Date: 09 January 2026
Our ref: 534905
Your ref: 2382/APP/2023/2906

Planning consultation: Amendment: Redevelopment of Site to create the Hillingdon Water sports Facility & Activity Centre and other associated works.

Location: Broadwater Lake, Moorhall Road, Harefield

SUMMARY OF NATURAL ENGLAND'S ADVICE

Project
HWSFAC
Drawing Title
Construction Phasing
Phase I

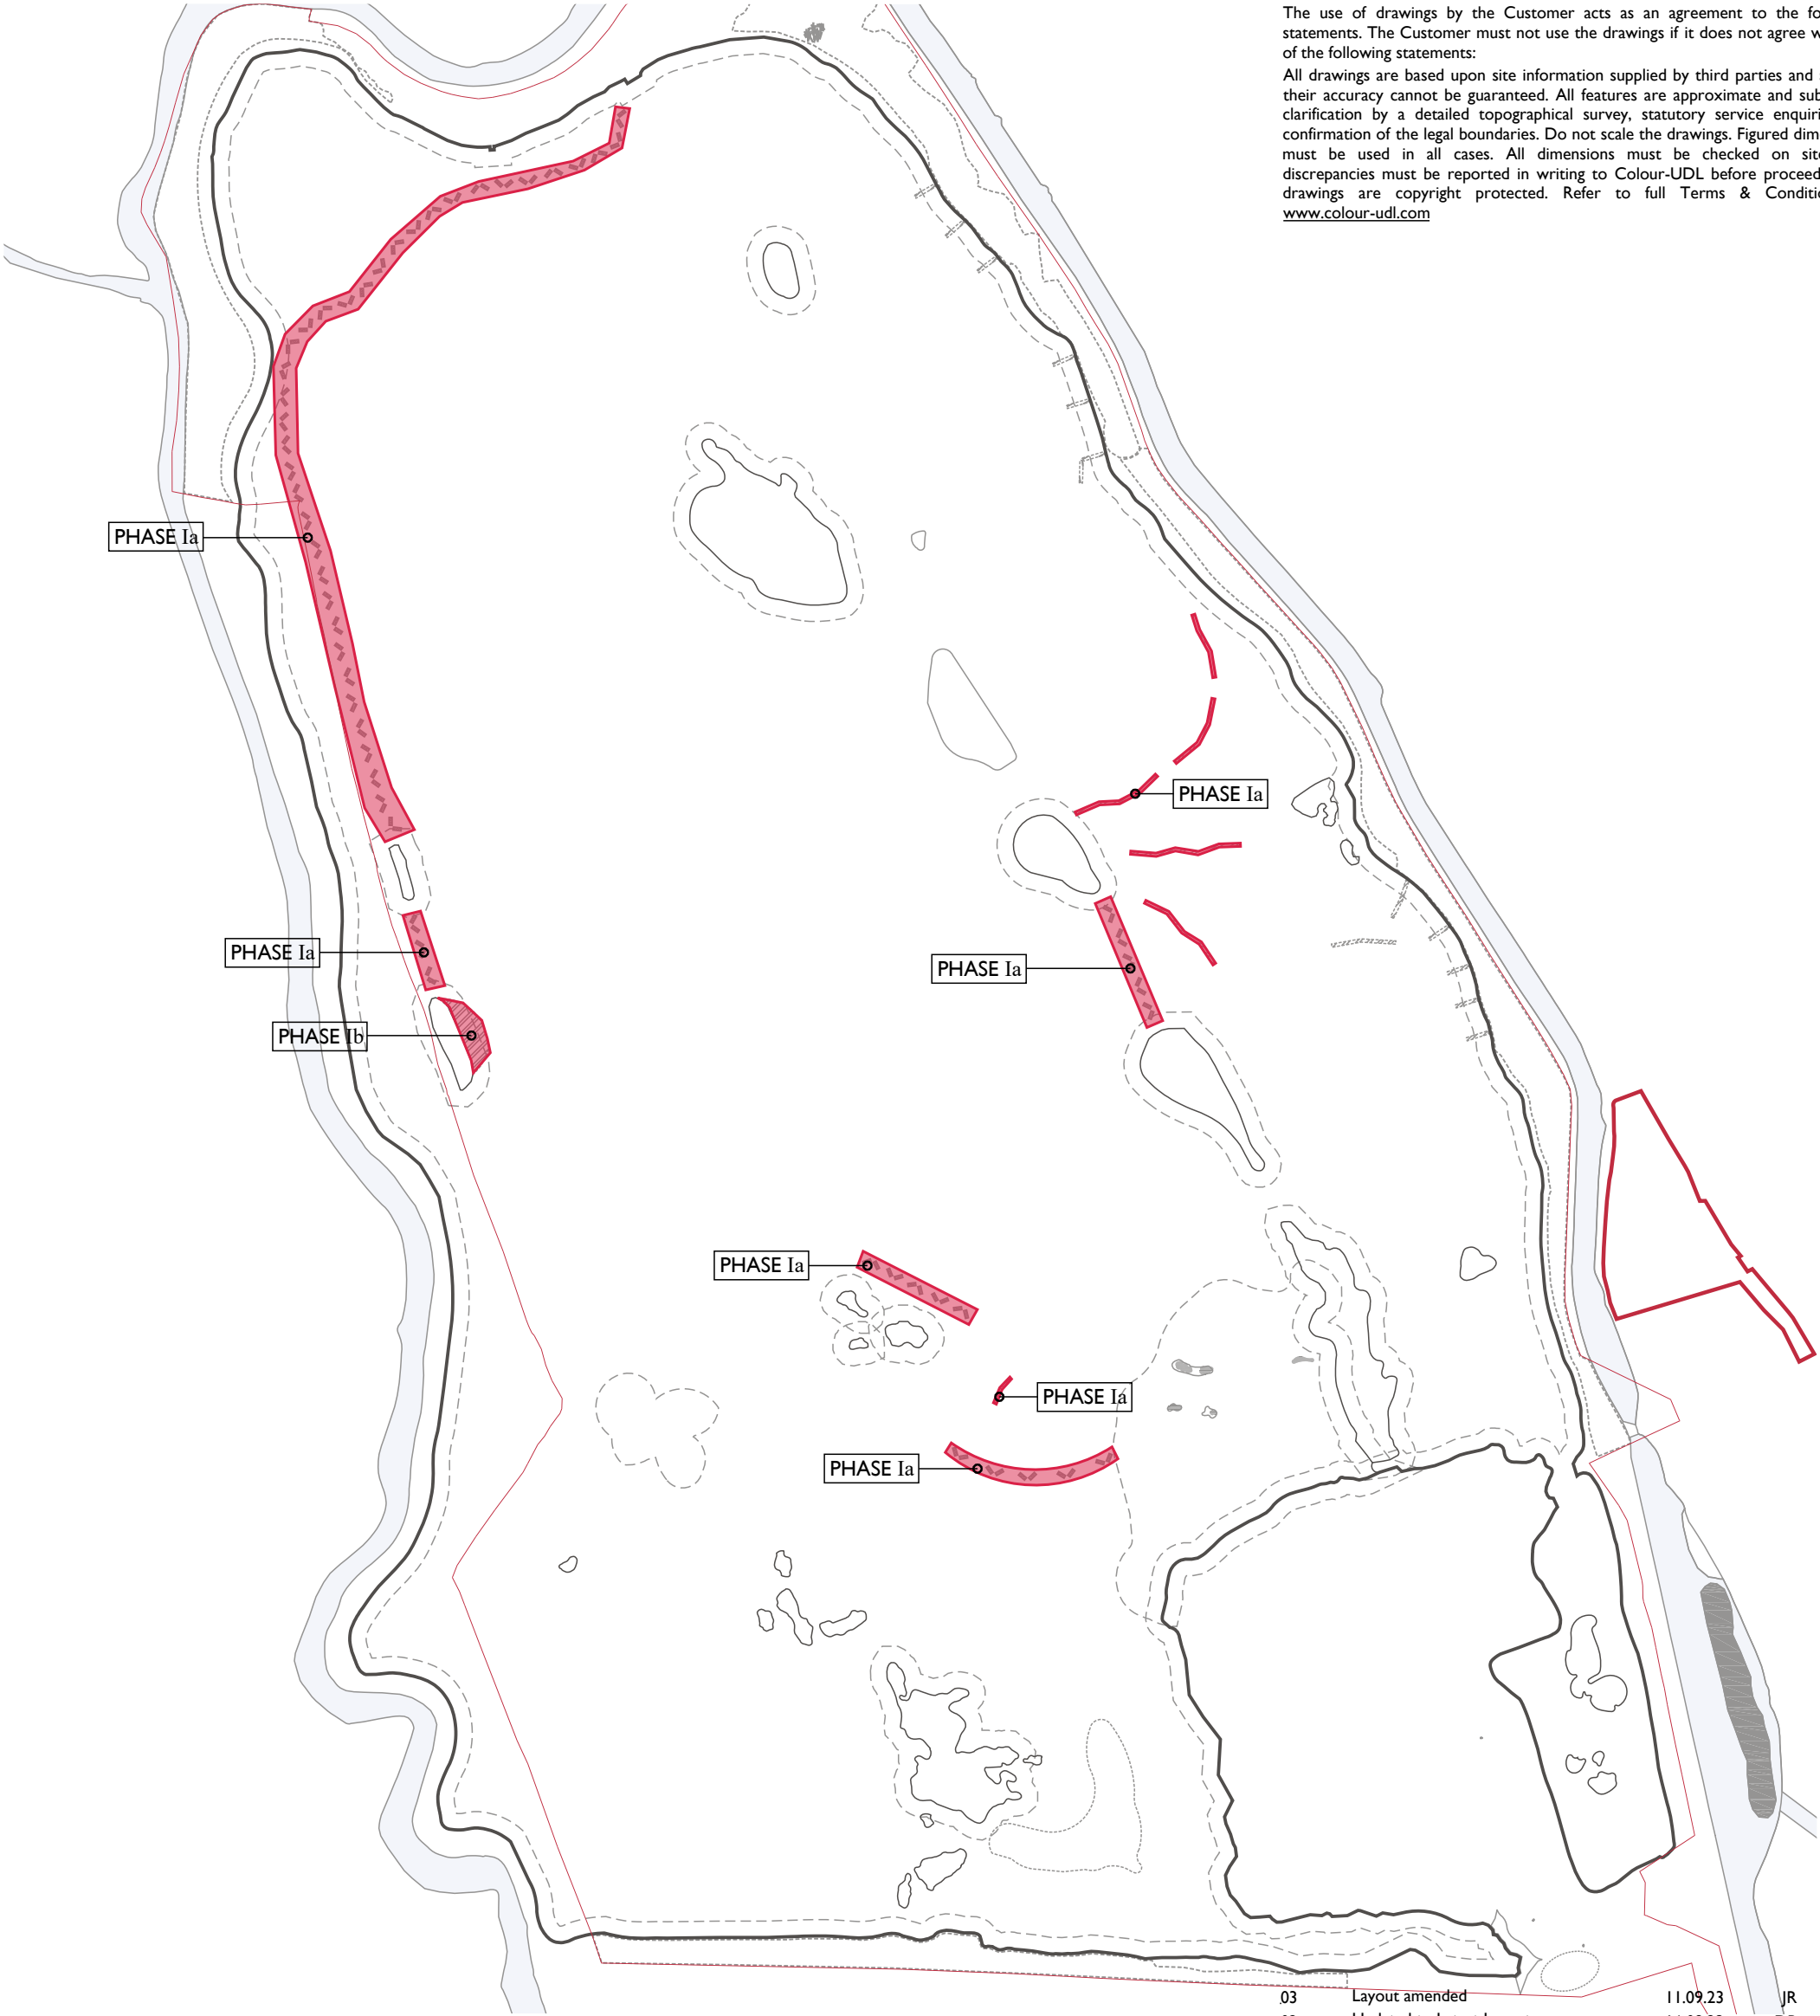
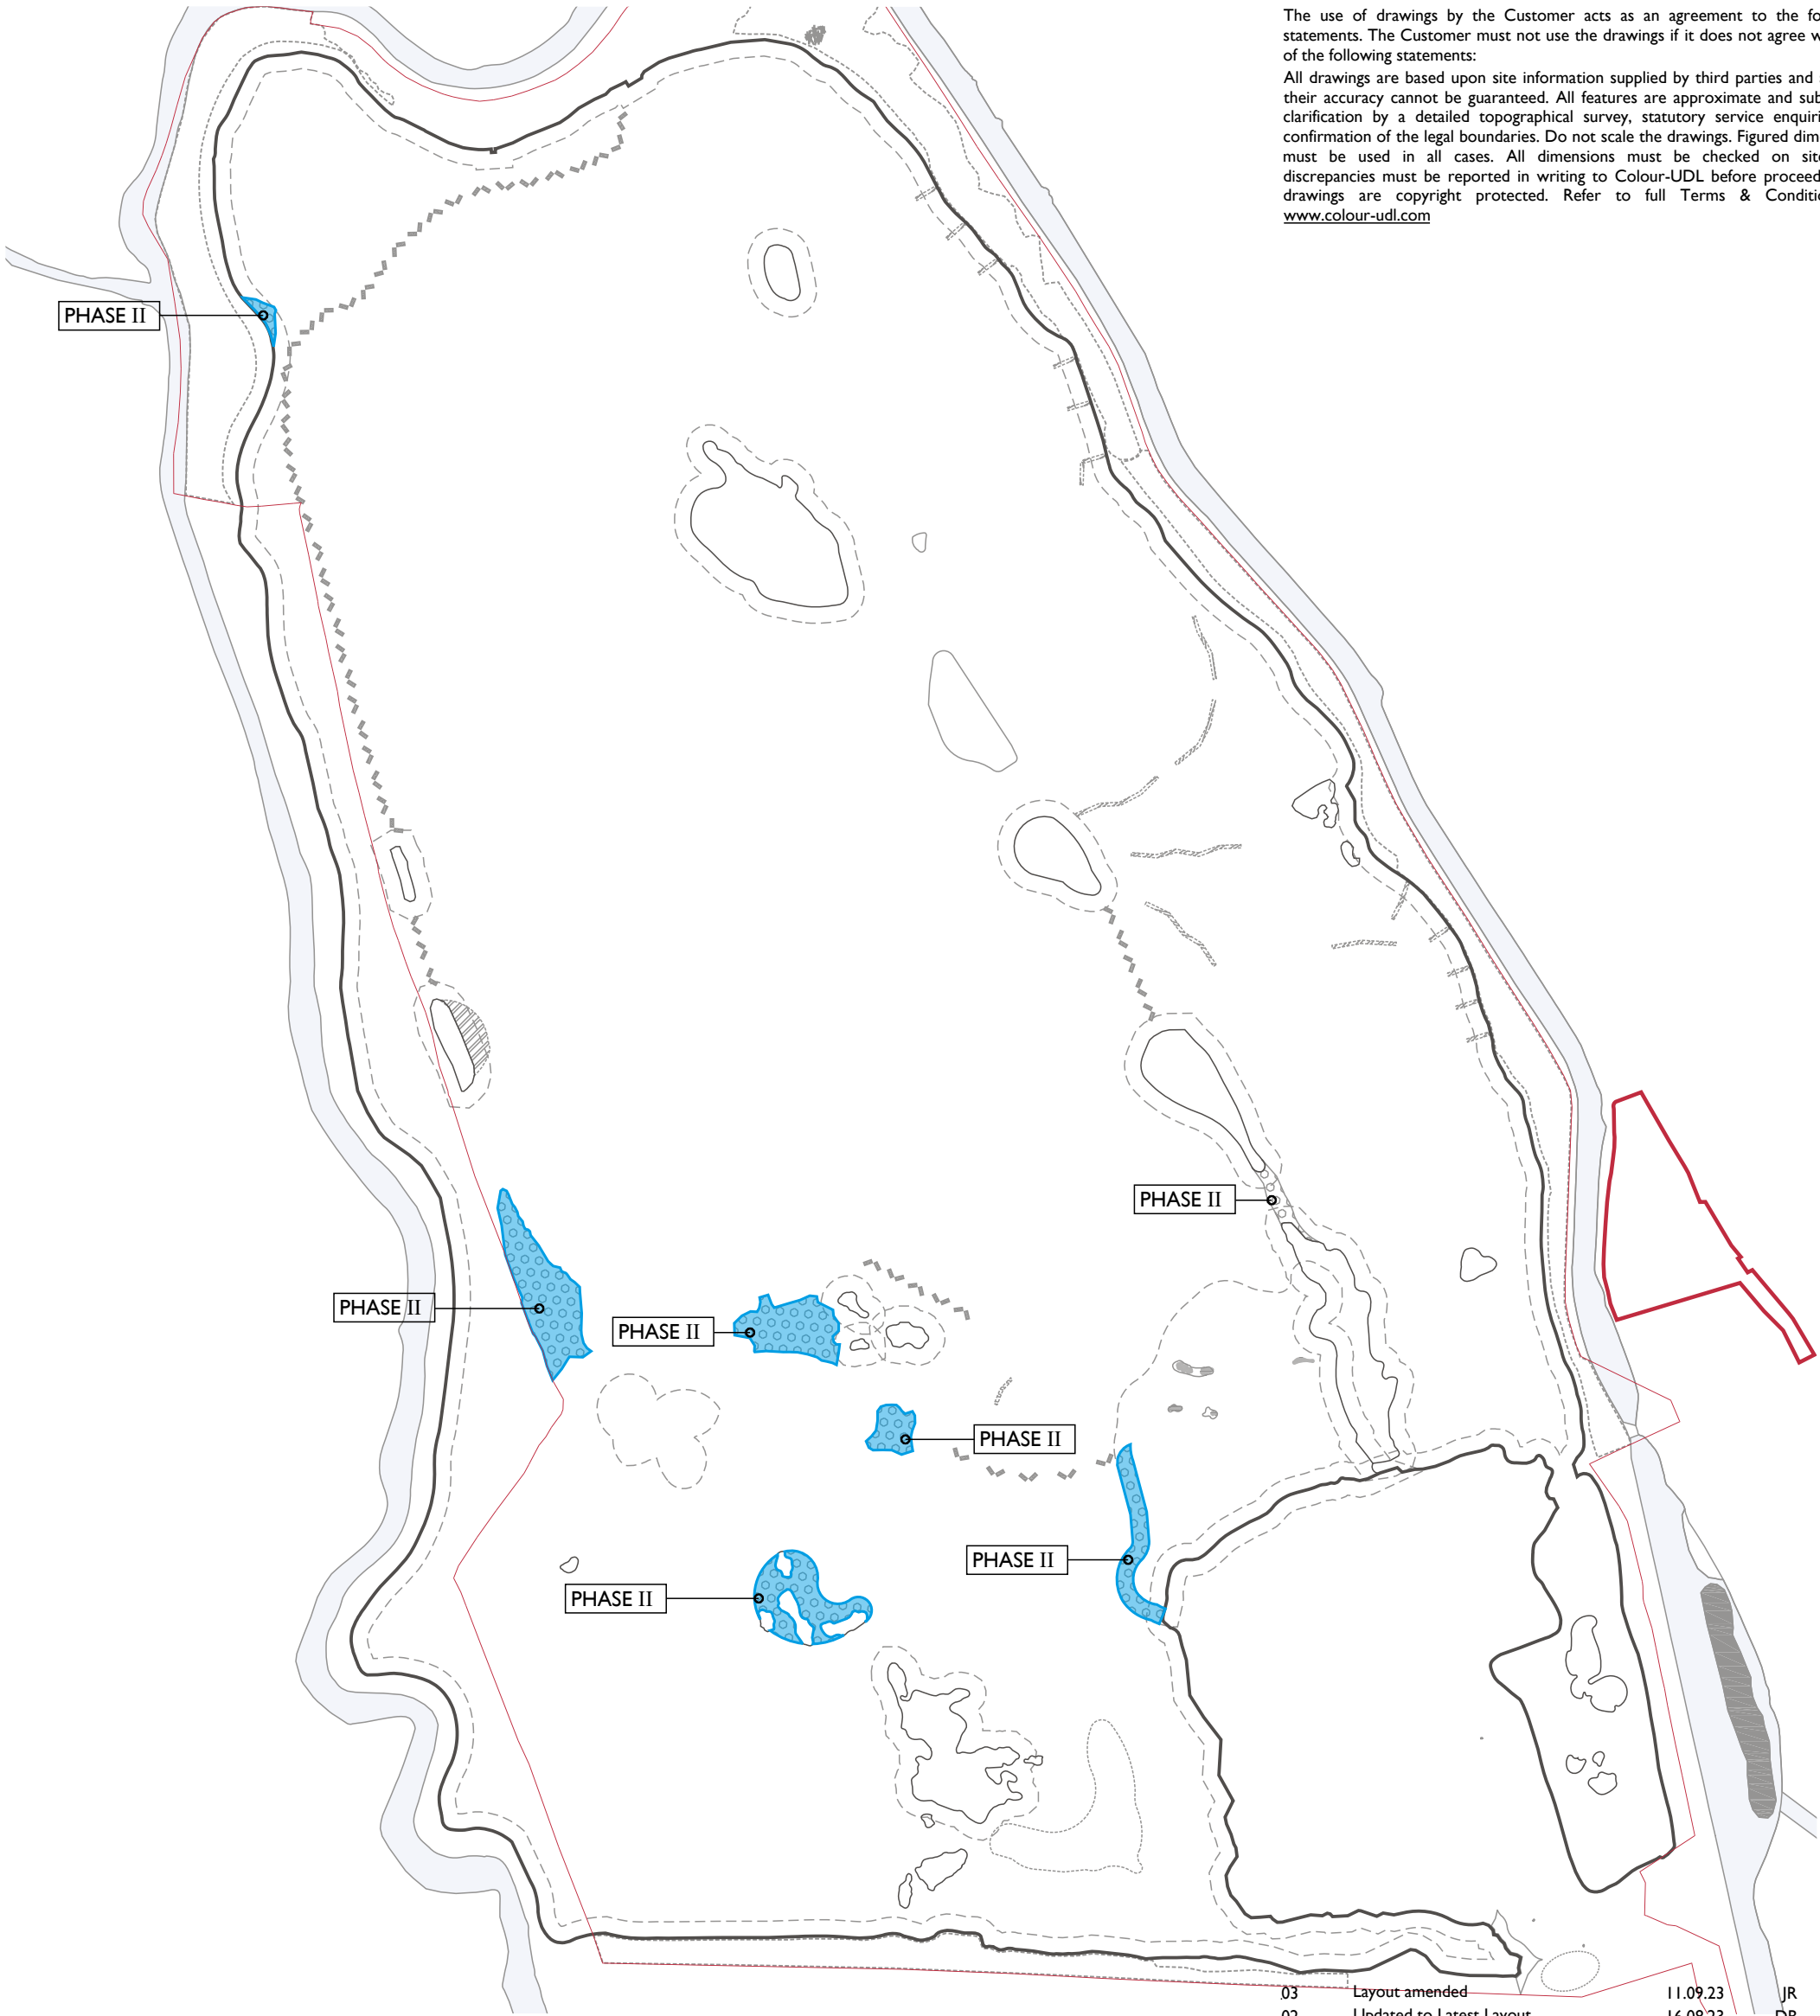
We apologise that we hadn't previously noted the importance of the site during the late summer months for the over wintering birds. We have reviewed the WeBS data for the site for the last three years and noted that in some years August and September have peak numbers of tufted ducks (*Aythya fuligula*). This information re-enforces the importance of the year-round refuge area on the lake, and the need to ensure that there is a refuge area during both construction and operation.

While Natural England view the refuge area as suitable mitigation to minimise impacts to moulting tufted duck numbers during operation, we would advise that construction schedules should be adjusted to take account of this. While we have previously advised that September is the best month for noisier construction activities, we now advise that these activities (such as demolition and piling) should take place during October – December. While these are still sensitive months and mitigation will be needed, this avoids the breeding and moulting season, and later winter months where it is likely to be colder with less food available for the wintering birds.
